Recommendation Report for Planning Permission for Works or Extension to a Dwelling

REF NO: AL/46/22/HH

LOCATION: 45 Ivy Lane
Westergate
Aldingbourne
PO20 3RE

PROPOSAL: Erection of single storey rear extension and conversion of loft to habitable use including the installation of 1 No. rear dormer with juliette balcony and 2 No. front rooflights.

Drawing Title
Proposed Redevelopment
Proposed Elevations

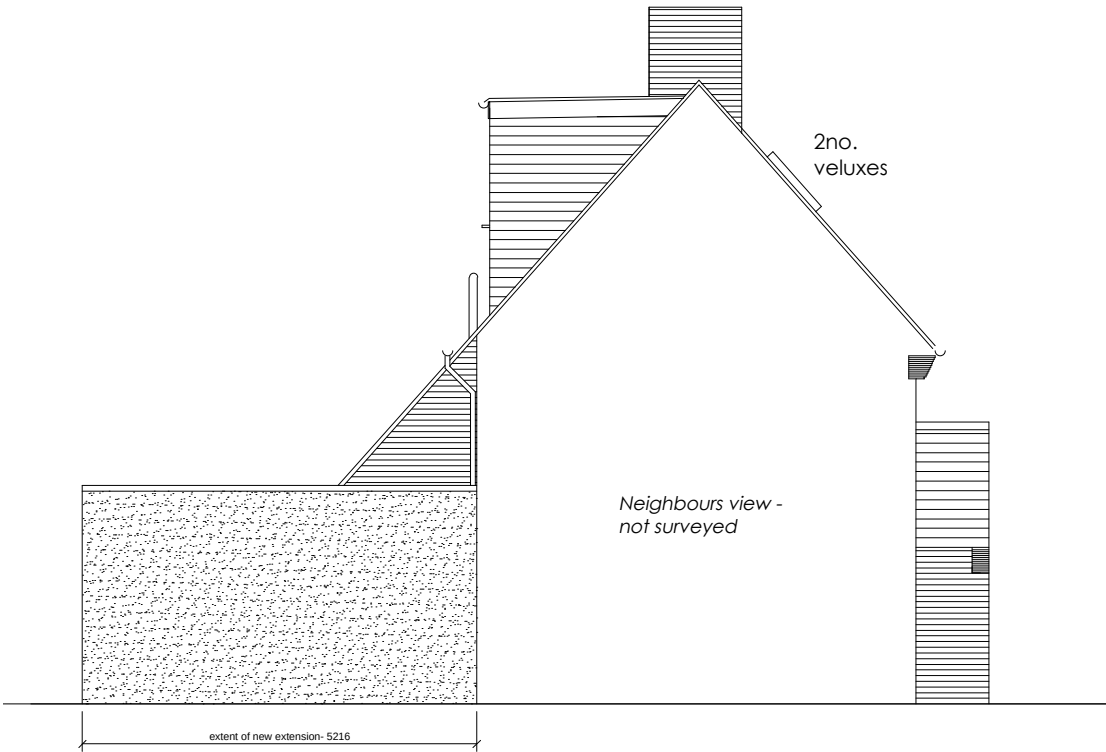
The Arun Design Guide states 'Favours small scale dormer windows with pitched roofs over large, flat box-shaped designs'. The proposal does not comply with this, being a large scale flat roof dormer, however the harm is reduced as there are no views available from the wider area and the design is a product of the unusual roof shape. With regards to the rear extension, the guide states 'Extensions should respond to and complement the existing character and appearance of the building and wider townscape in terms of scale, massing, materials, openings and roof form'. 'Extensions of over 50% of existing floorspace unlikely to be considered acceptable'. The proposal complies as it is not over 50% of the floorspace.

The dormer will have a height of 2.75m, a depth of 2m and length of 6.45m. This retains around 1m to the side boundaries and around 2.3m to the eaves. The dormer appears large although a similar proposal is likely to be achievable under permitted development and refusal is not justified. The dormer will have a Juliet balcony and 2 windows serving a bedroom area. This will result in some additional views upon neighbouring gardens which are not currently achievable however this will not result in views direct into properties and there no dwellings directly to the rear.

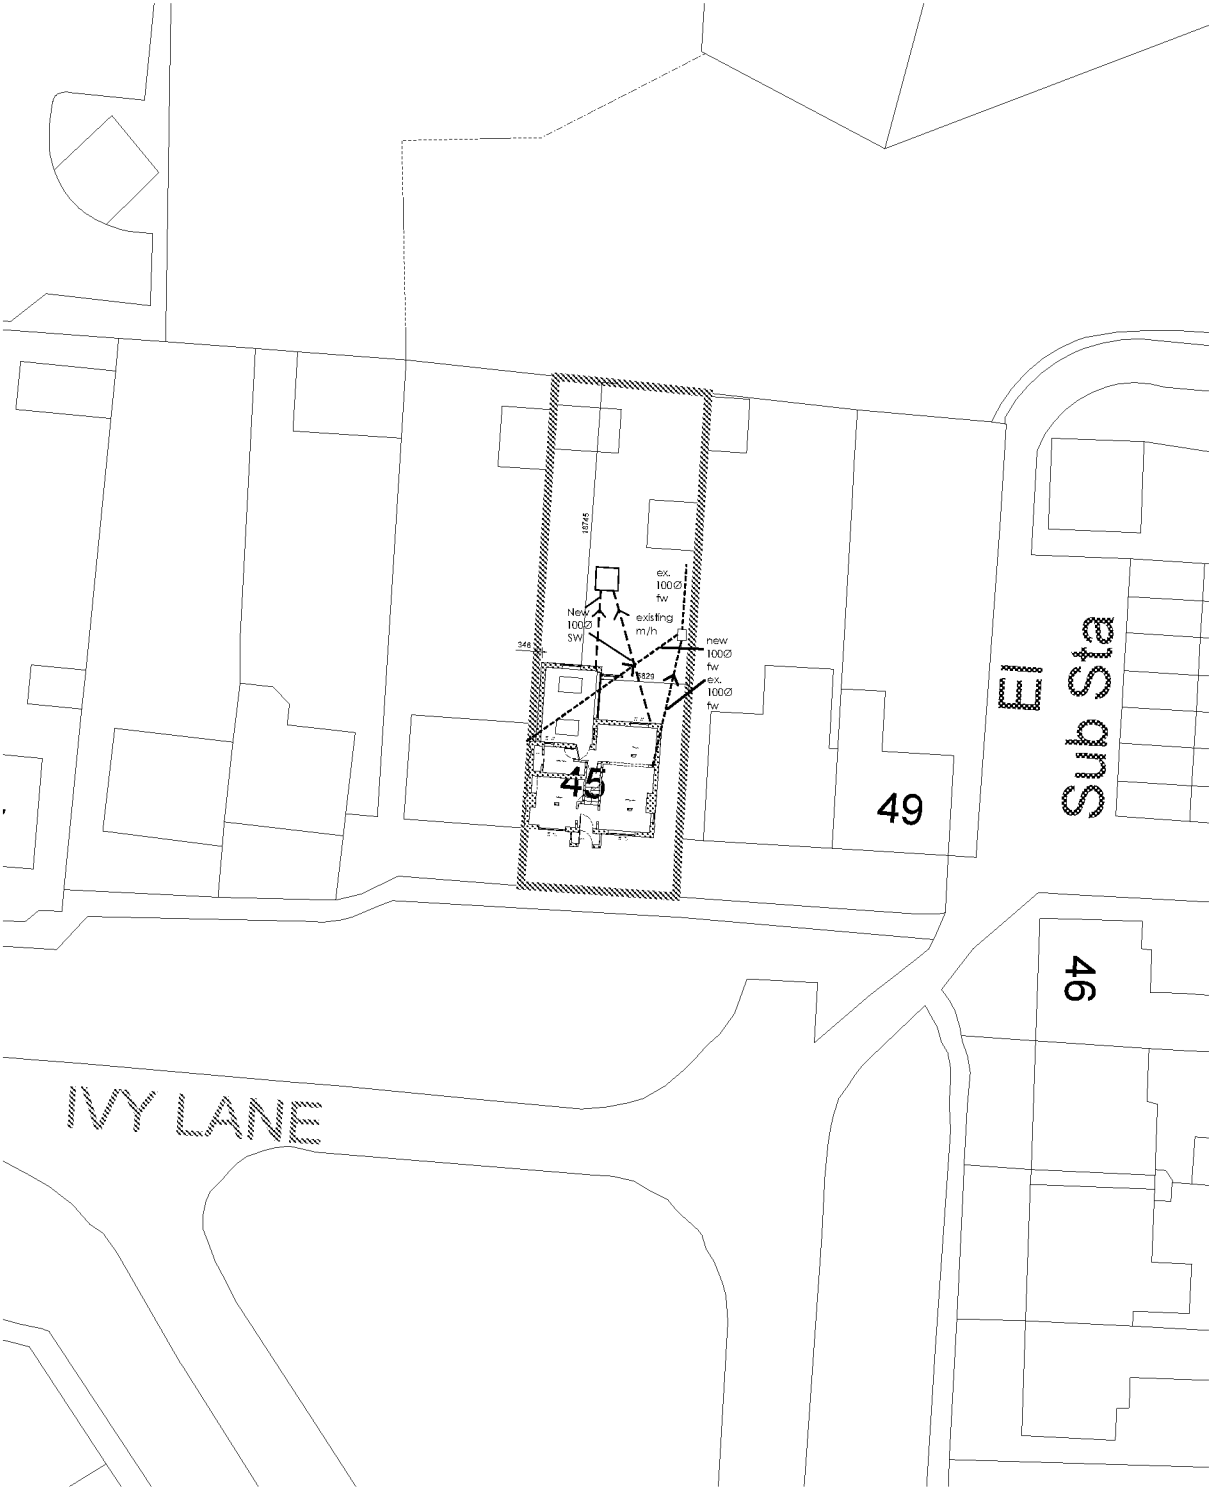
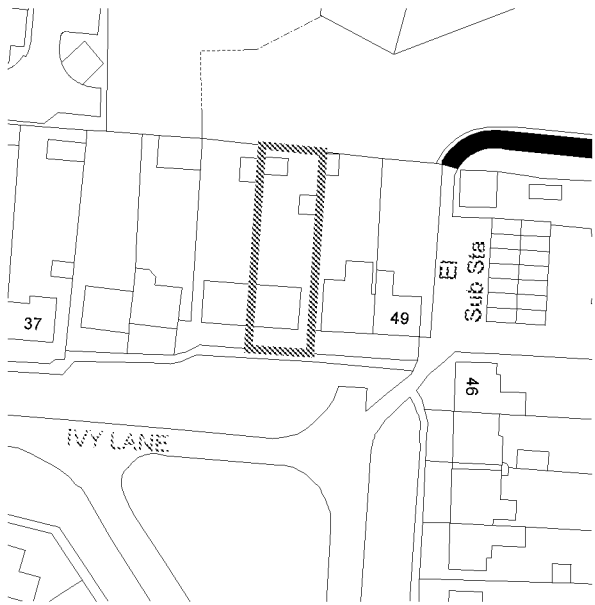
- Apply standard pre commencement surface water drainage condition due to its location within the Lidsey Catchment Area.

The host property is semi-detached and has a cat slide roof to the rear. The extension and dormer add some bulk to the rear as a result of their size although approximately 18m is retained to the rear boundary and it does not appear an overdevelopment of the plot.

This has been agreed with the agent.

Drawing Title  
Proposed Redevelopment  
Proposed Floor Plans

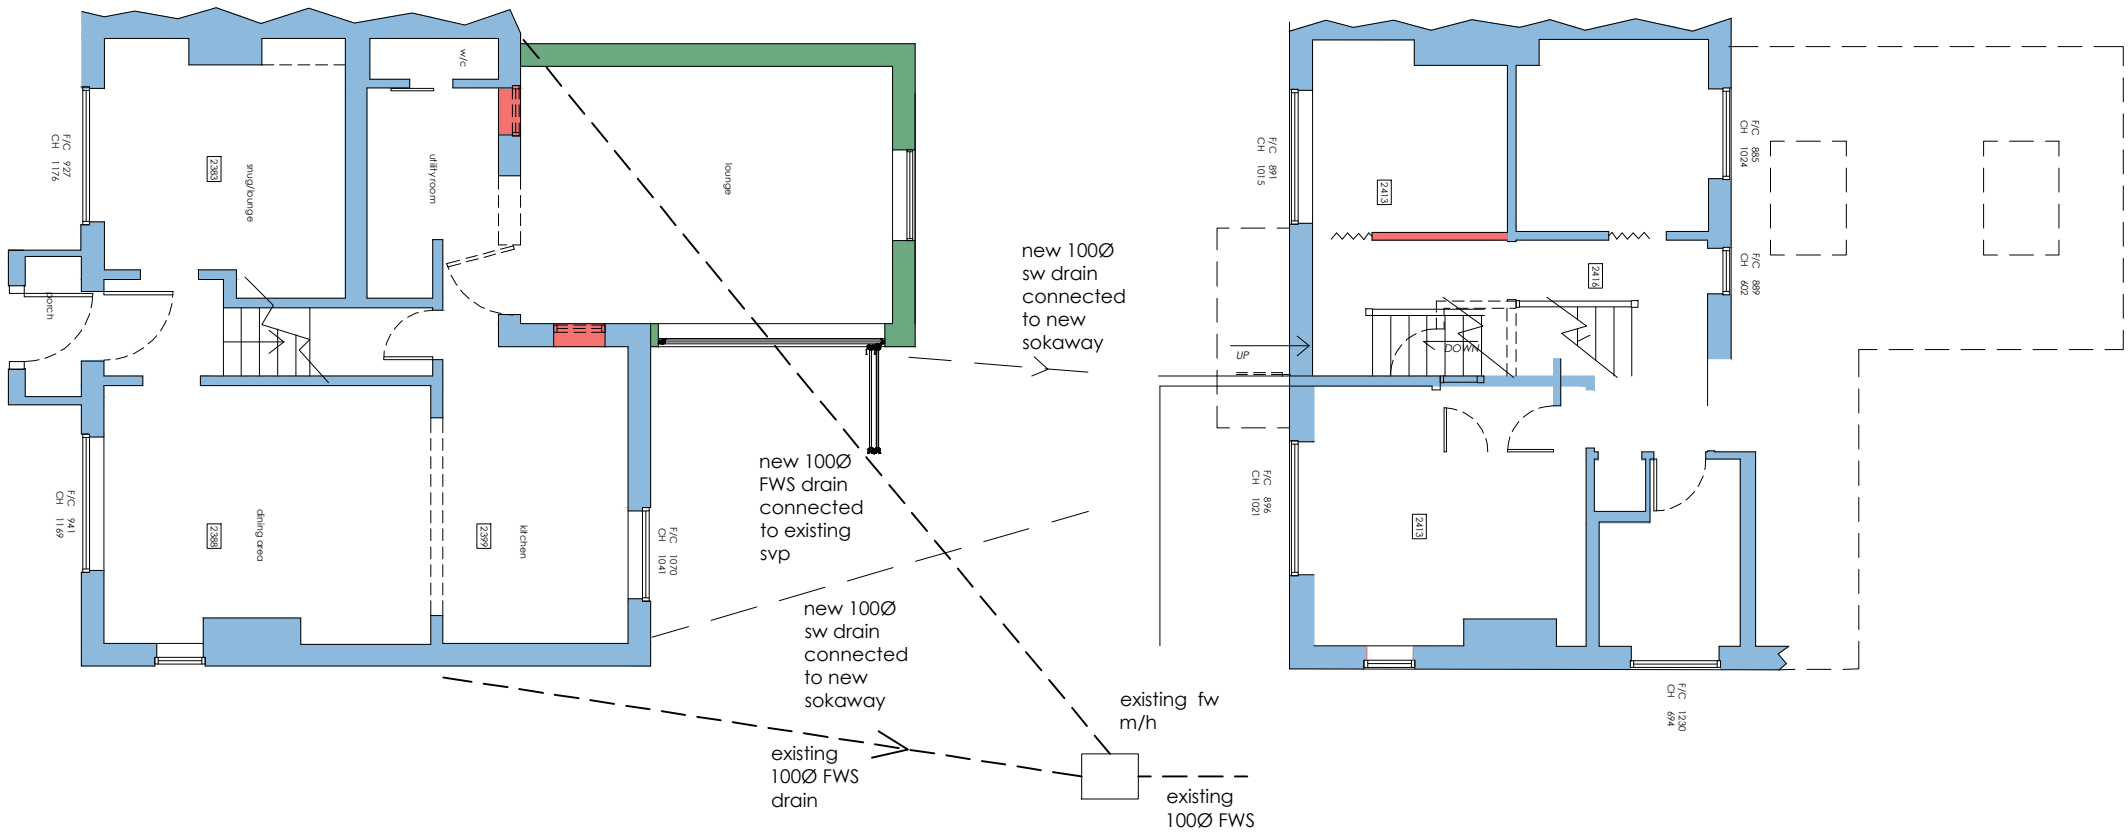
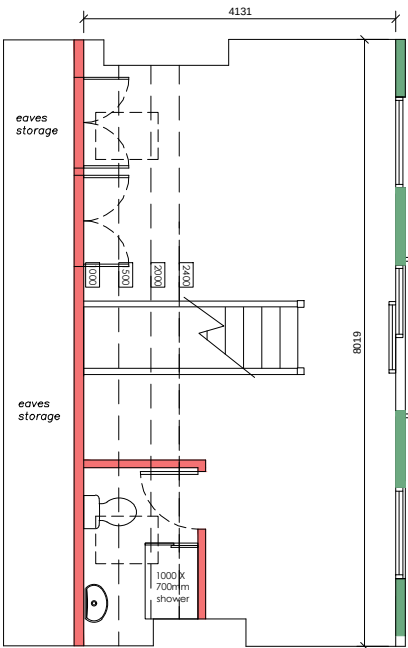
The extension is to the western side and will have a total depth of 5.2m. This will have a width of 4m retaining 5.8m to the eastern side. The extension will have a flat roof to a height of 2.75m.

The Council uses a 45-degree rule to assess serious effects on neighbouring properties. The development due to its siting, intersects a 45-degree angle when drawn from the centre of the ground floor rear window at the neighbouring property at No.43 and will result in some overbearing and overshadowing in the morning. However, an extension could be constructed up to this depth with prior approval with no objections from the neighbours and with no representation received, the development is considered acceptable.
